KITTITAS COUNTY

MEMORANDUM

TO: All Staff
FROM: Public Works Plan Review Team
DATE: May 25, 2021
SUBJECT: BL-21-00010 No. 9 Ranch 2

The Public Works Department has reviewed the Boundary Line Adjustment Application and has the following comments:

NO. 9 RANCH PROPERTY

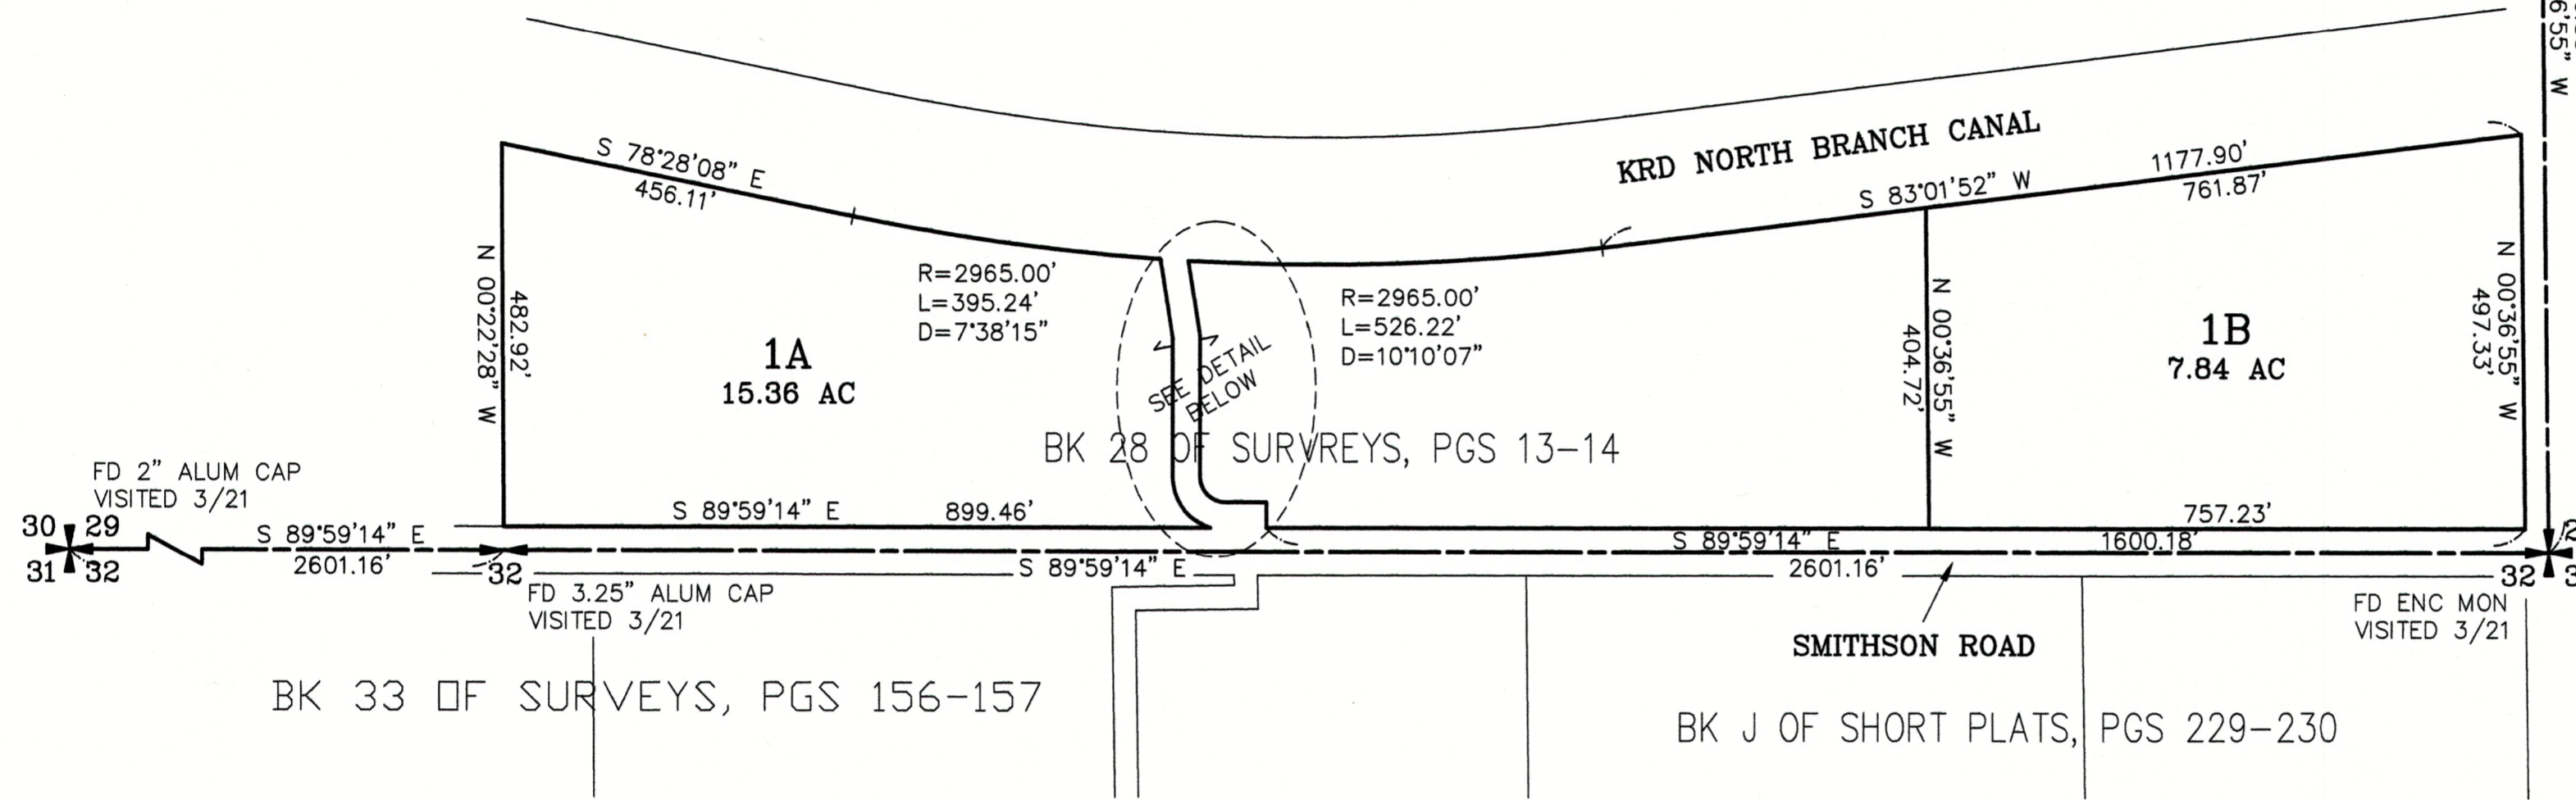
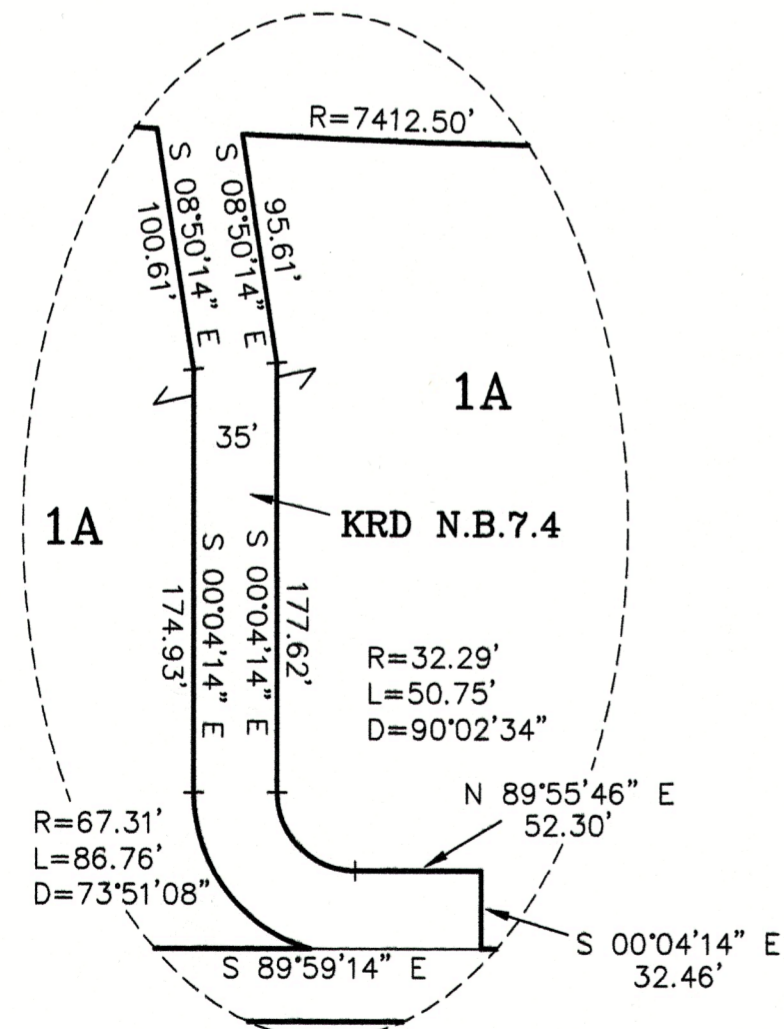
- a. An approved access permit shall be required from the Kittitas County Department of Public Works prior to creating any new driveway access or changing an existing access. Please be aware parcel 19309 has an agricultural access that does not meet spacing requirements. This access must be removed at the time a residential access is applied for.
- b. Maintenance of driveway approaches shall be the responsibility of the owner whose property they serve. The County will not maintain accesses.
- c. Any further subdivision or lots to be served by proposed access may result in further access requirements. See Kittitas County Road Standards.
- d. Access is not guaranteed to any existing or created parcel on this application.
- e. Any comments regarding survey will be reserved until final.
